Statement of Common Ground with the Environment Agency (draft)

August 2025

- 1.1.1 This Statement of Common Ground (hereafter referred to as the 'SoCG') has been prepared to support the Examination of the Development Consent Order (DCO) application (the 'DCO Application') for Peartree Hill Solar Farm (the 'Proposed Development').

#### Figure 3.6: Indicative Culvert Crossing Points

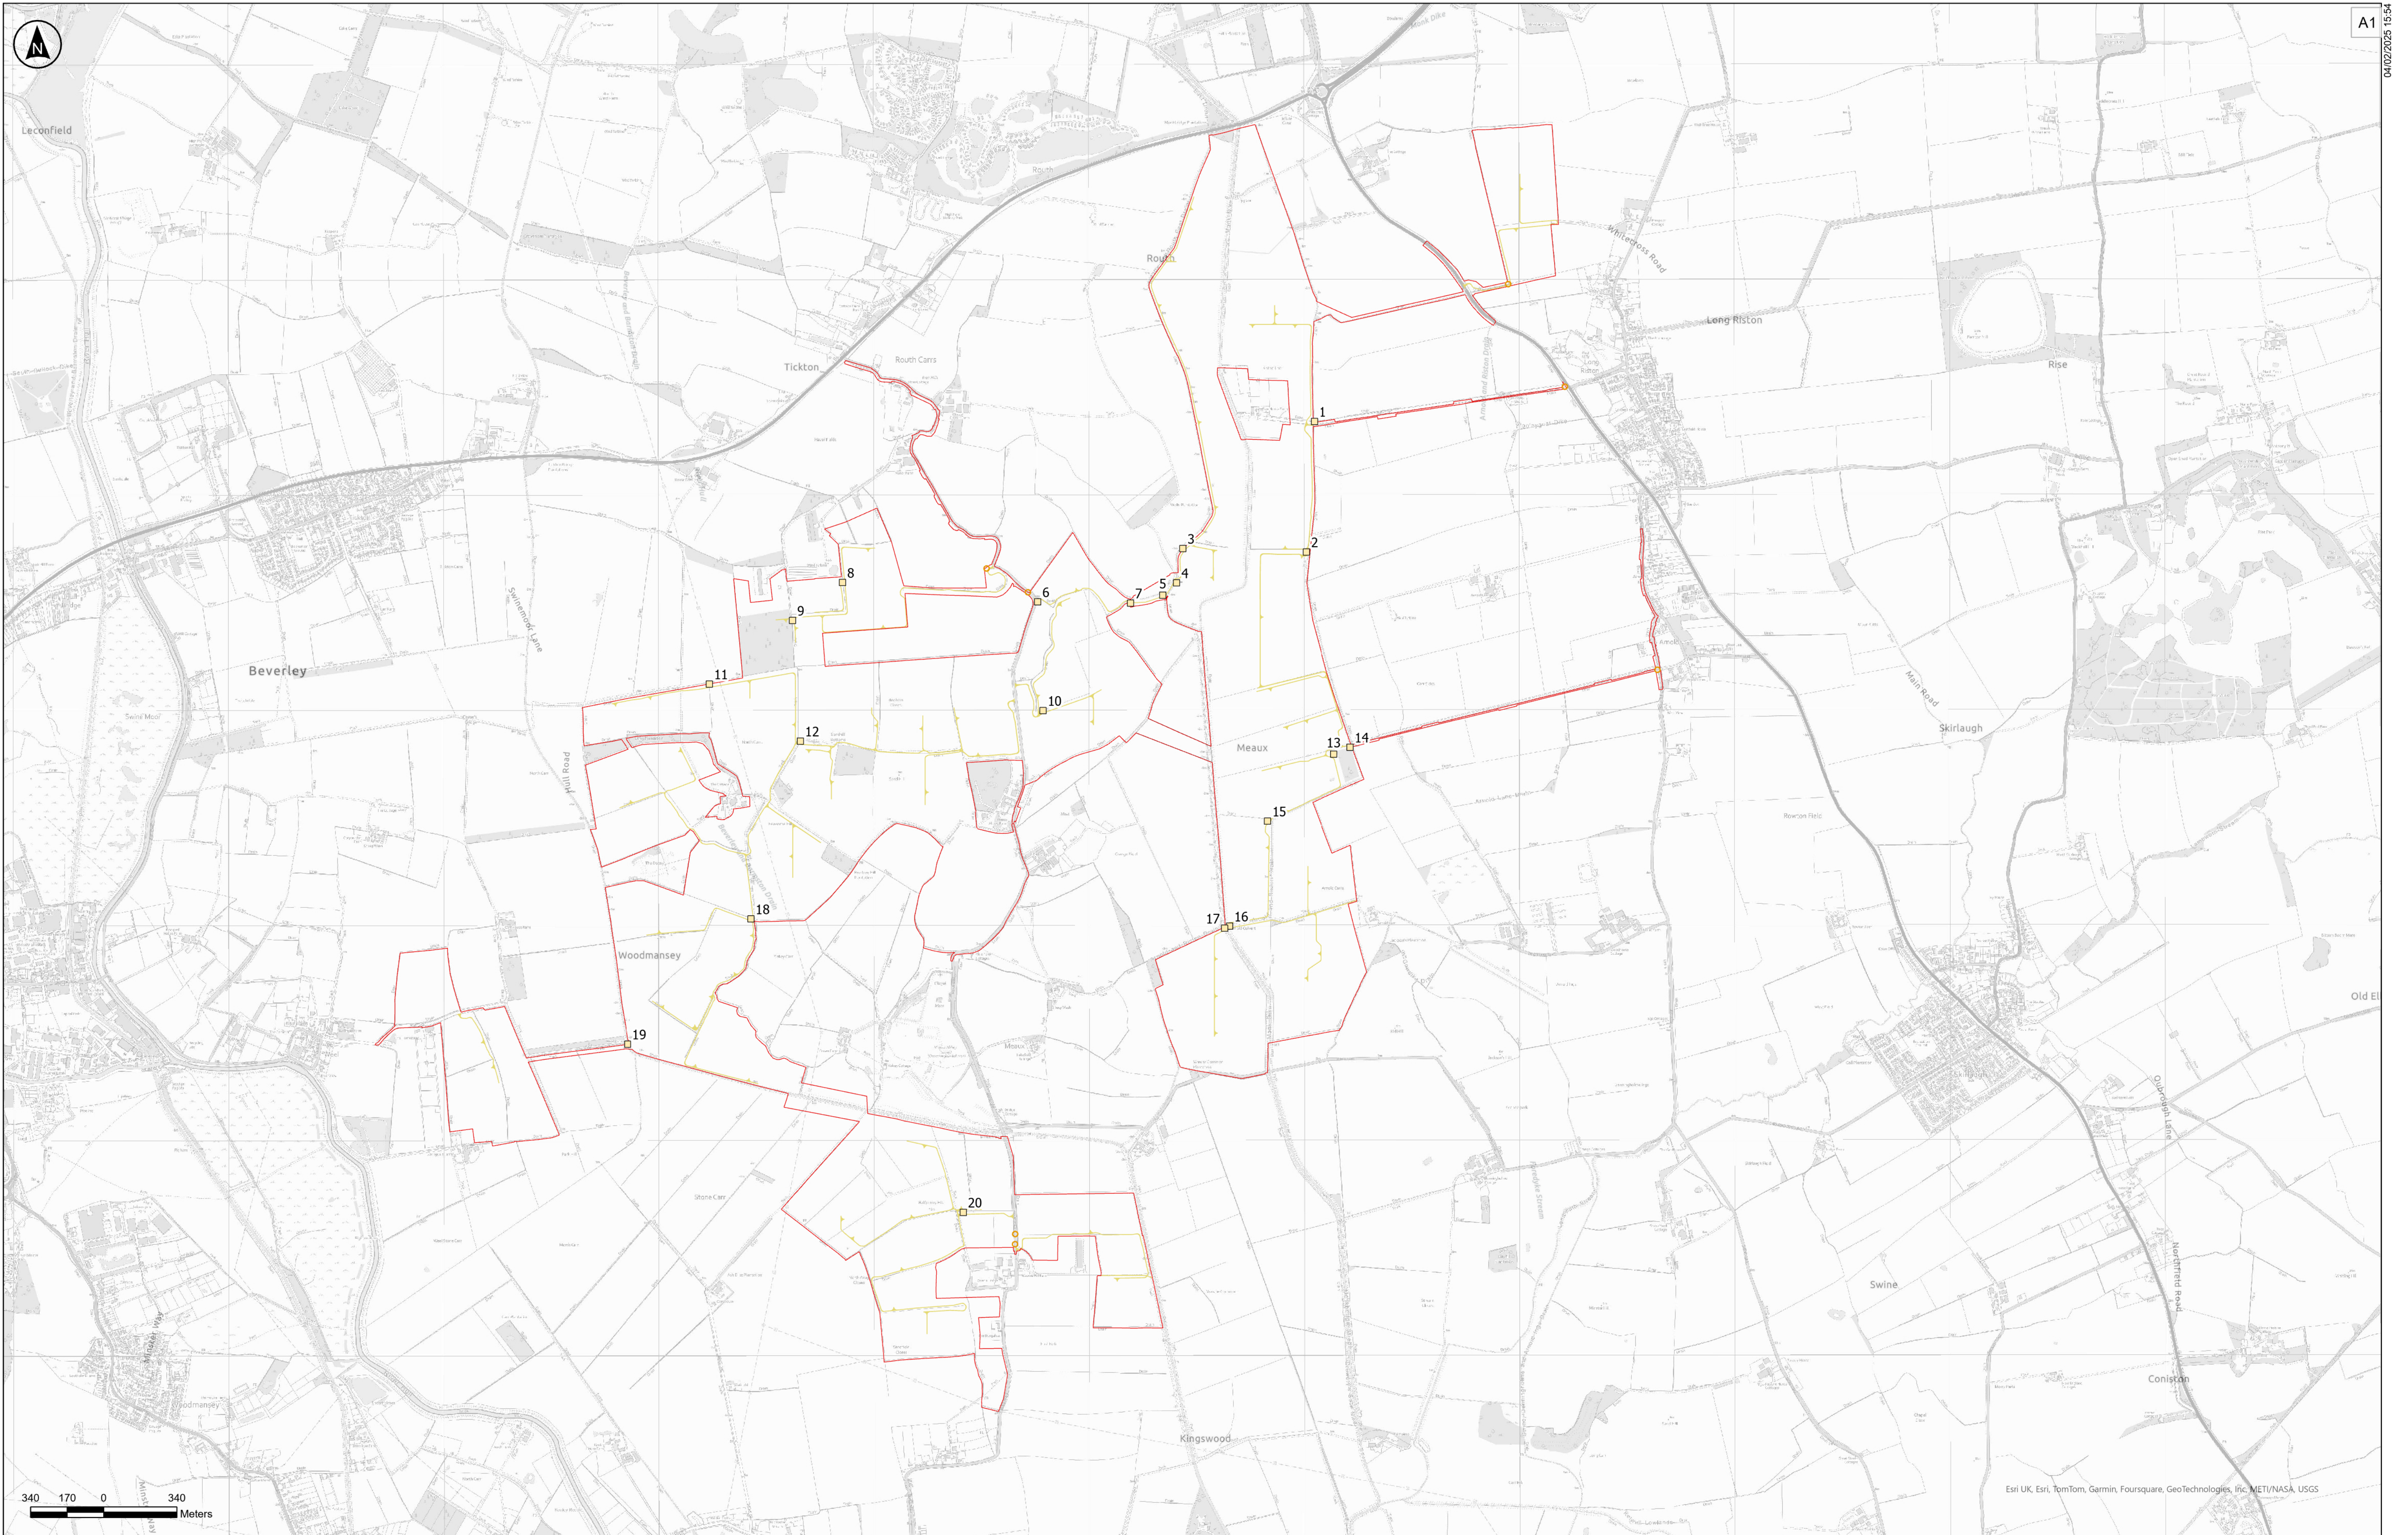
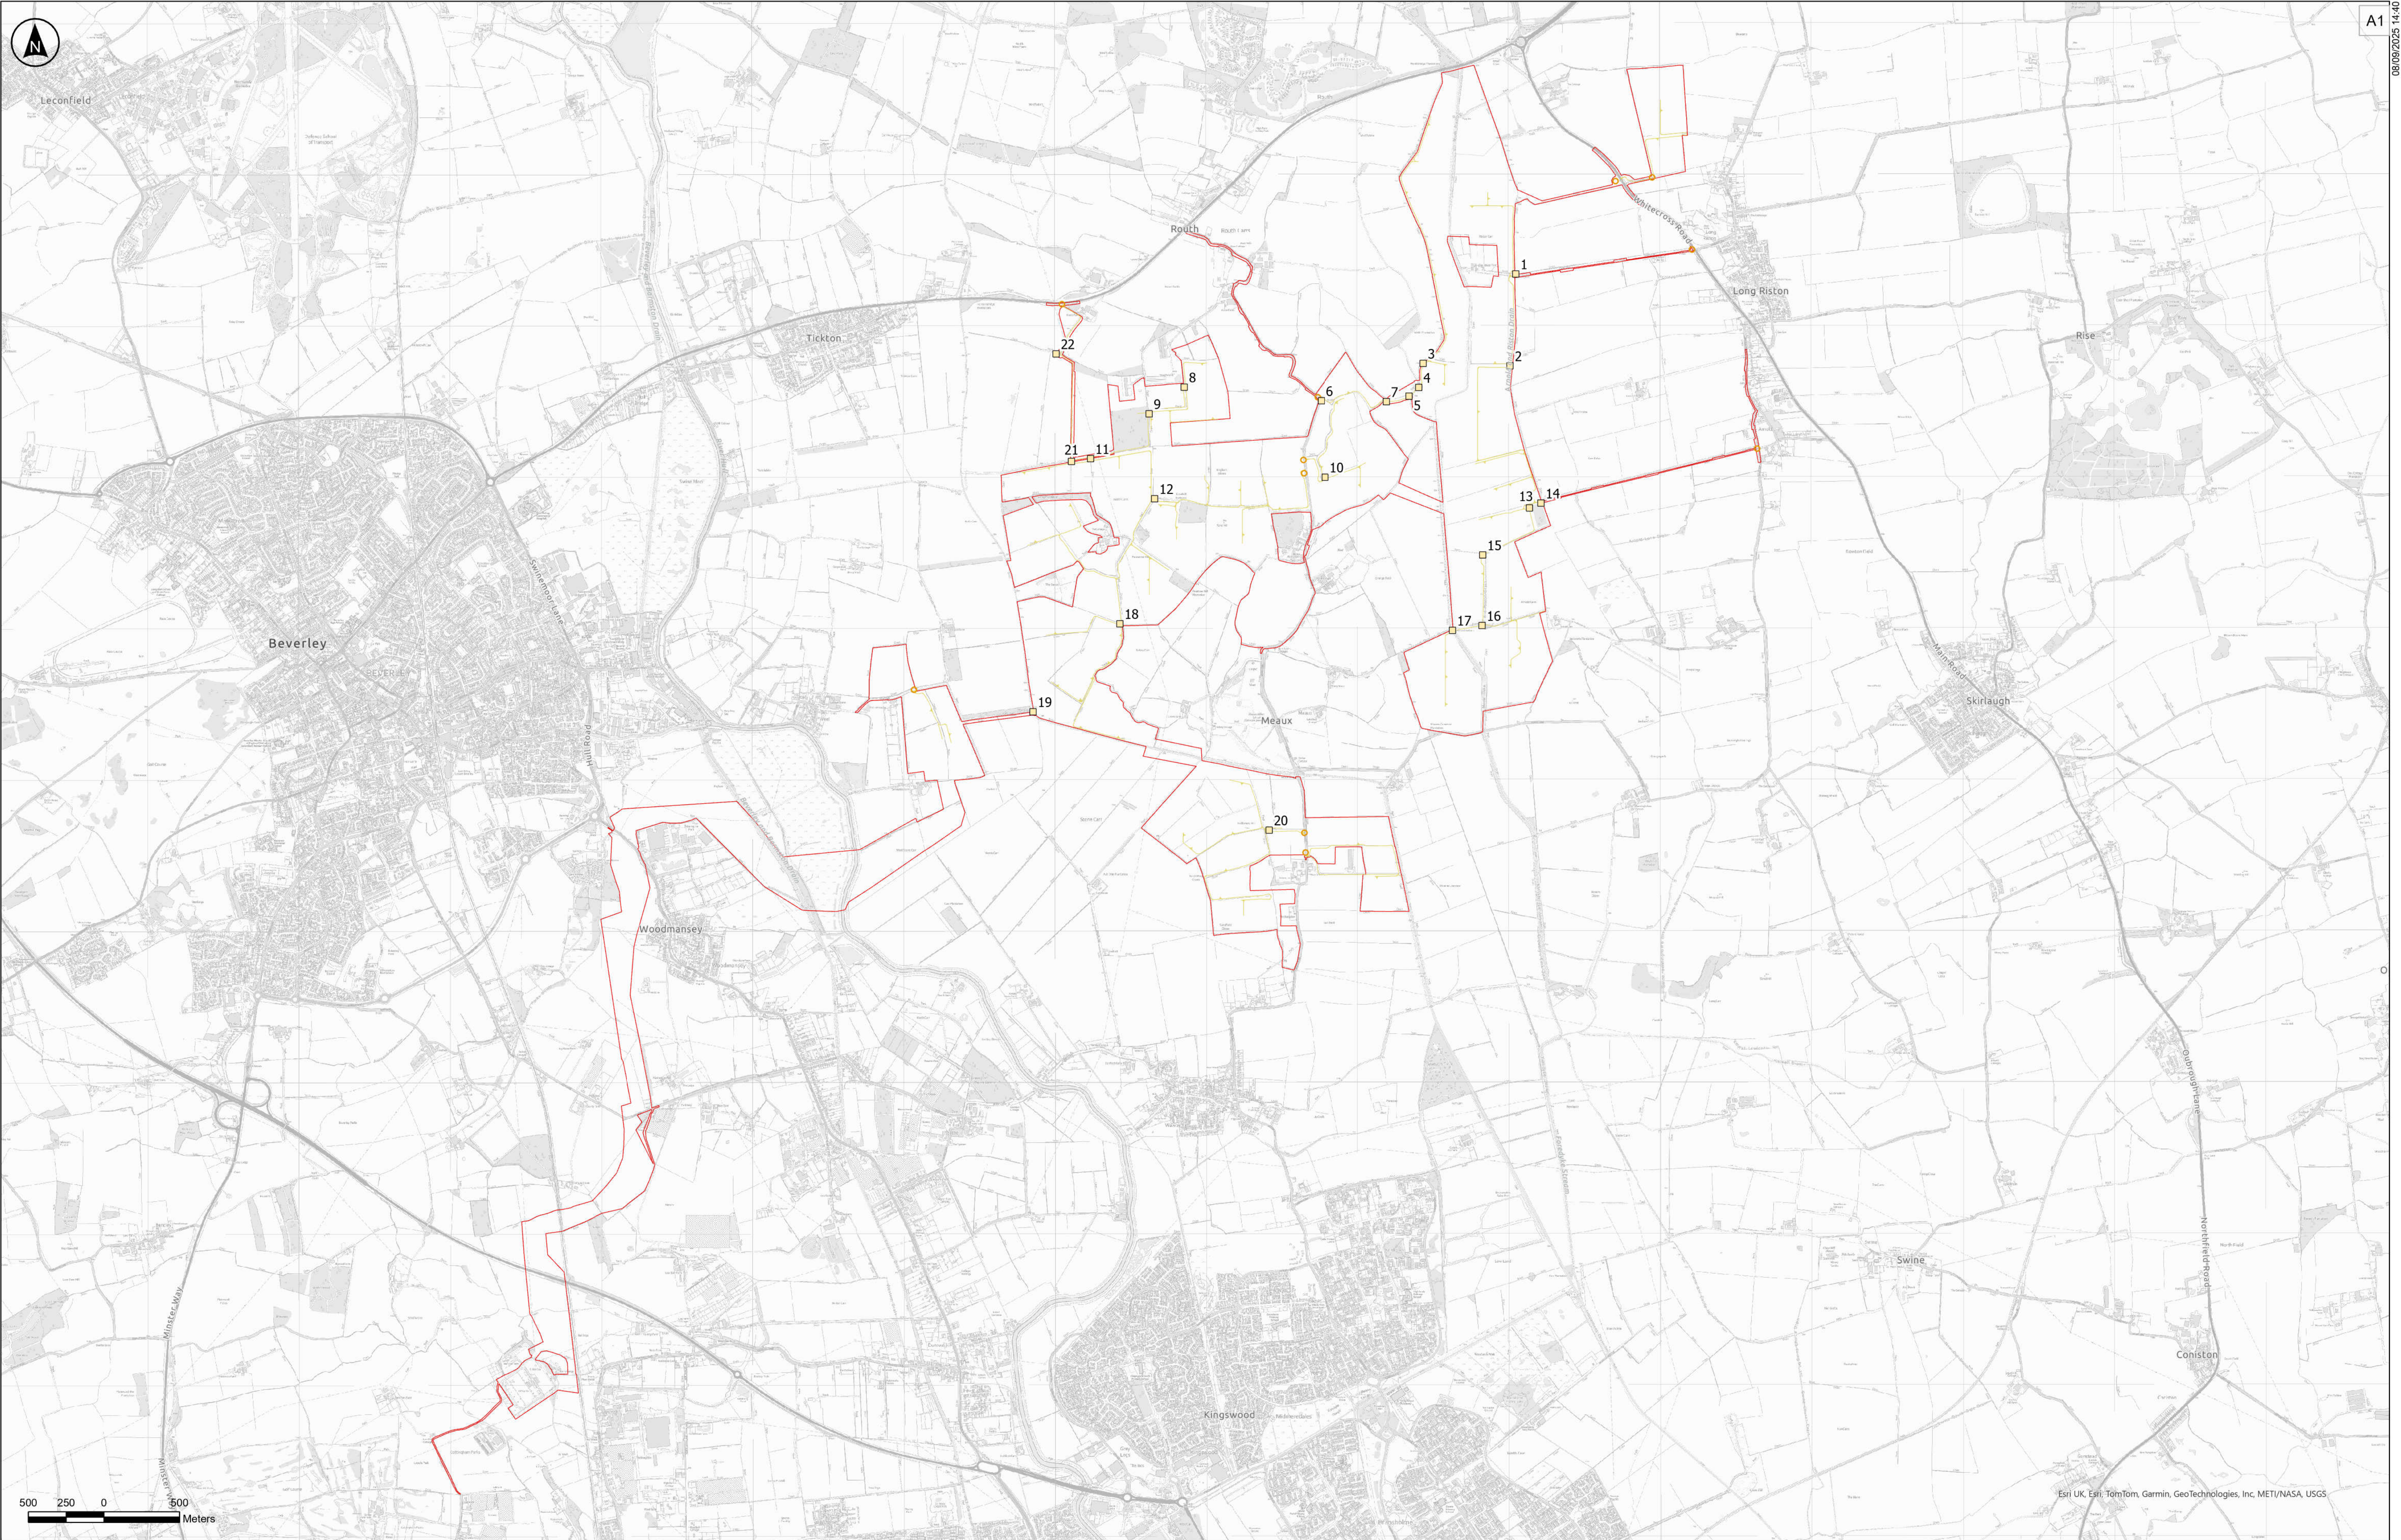
Ref	Topic	Environment Agency's Position	Applicant's Position	Status
EA10	Impacts on flood defences <i>Hydrology and Flood Risk</i>	In their relevant representation [RR-005] (EA12), the Environment Agency requests that the Applicant confirm crossing types for all crossings and provide drawings for areas where there is potential for interaction with flood defences (within 8 metres of landward toe), confirming minimum distances. Any below ground crossings should investigate any interactions with embankments or other structures and ensure they do not compromise flood defence foundations.	It is the Applicant's intention to utilise existing culvert crossings and/or bridge structures where possible. Pre-construction structural surveys will be undertaken to determine the most appropriate crossing at each location (it is expected that the pre-construction surveys would result in the number of new culverts required to be lower than is shown on ES Volume 3, Figure 3.6: Indicative Culvert Crossing Points [APP-060]). Crossing design is controlled by the protective provisions within the Draft Development Consent Order [EN010157/APP/3.1 Revision 4] , which require a detailed design to be submitted to the Environment Agency for approval at the detailed design stage.	Under discussion

Waste				
EA22	Waste Management Strategy <i>Waste</i>	In their relevant representation [RR-005] (Appendix C), the Environment Agency indicates that it is satisfied with the Applicant's approach to waste management.	The Applicant welcomes this response. Waste management measures are set out in the relevant management plans, including the Outline Operational Environmental Management Plan [EN010157/APP/7.3 Revision 2] , Outline DEMP [EN010157/APP/7.4 Revision 2] and Outline Site Waste Management Plan [APP161] .	Agreed
Geomorphology				
EA23	Use of Culverts	In their relevant representation [RR-005] (EA06), the Environment Agency requests	It is the Applicant's intention to utilise existing culvert crossings and/or bridge structures where	Under discussion

Ref	Topic	Environment Agency's Position	Applicant's Position	Status
	<i>Hydrology and Flood Risk</i>	that the Applicant avoid the use of culverts wherever possible. Should there be no reasonable alternative to installing a new culvert, clear justification must be given, including any reasons why the culvert is required beyond the construction phase, and impacts should be assessed across all phases if needed. Where existing culverts require upgrading/ reinforcing due to project needs, the Applicant should consider replacing them with clear span options.	<p>possible. For the purposes of the assessment, 20 locations (see ES Volume 3, Figure 3.6: Indicative Culvert Crossing Points [APP-060]) are assumed to require either the installation of a temporary span bridge or culvert, or reinforcement or widening of the existing culvert/bridge structure. To ensure a worst-case scenario has been assessed, it has been assumed that all existing crossings will require a new culvert structure. It is however expected that following pre-construction structural surveys the number of new culverts required would be lower.</p> <p>The crossings over minor watercourses, which are likely to be wet for much of the year, would be facilitated by box culverts. These would be fitted with a mammal shelf and the bed substrate would match that of the watercourse within the vicinity of the crossing.</p>

EA24	<p>Culverts – Post Decommissioning</p> <p><i>Hydrology and Flood Risk</i></p>	In their relevant representation [RR-005] (EA07), the Environment Agency notes that culverts are proposed to remain in-situ after decommissioning and requests that the Applicant fully consider the need for culverts across all phases of the Proposed Development. Should there be no reasonable alternative, the Applicant should consider what impact the removal of culverts (if installed/reinforced) would	The Applicant will continue to engage with the Environment Agency on this matter.	Under discussion
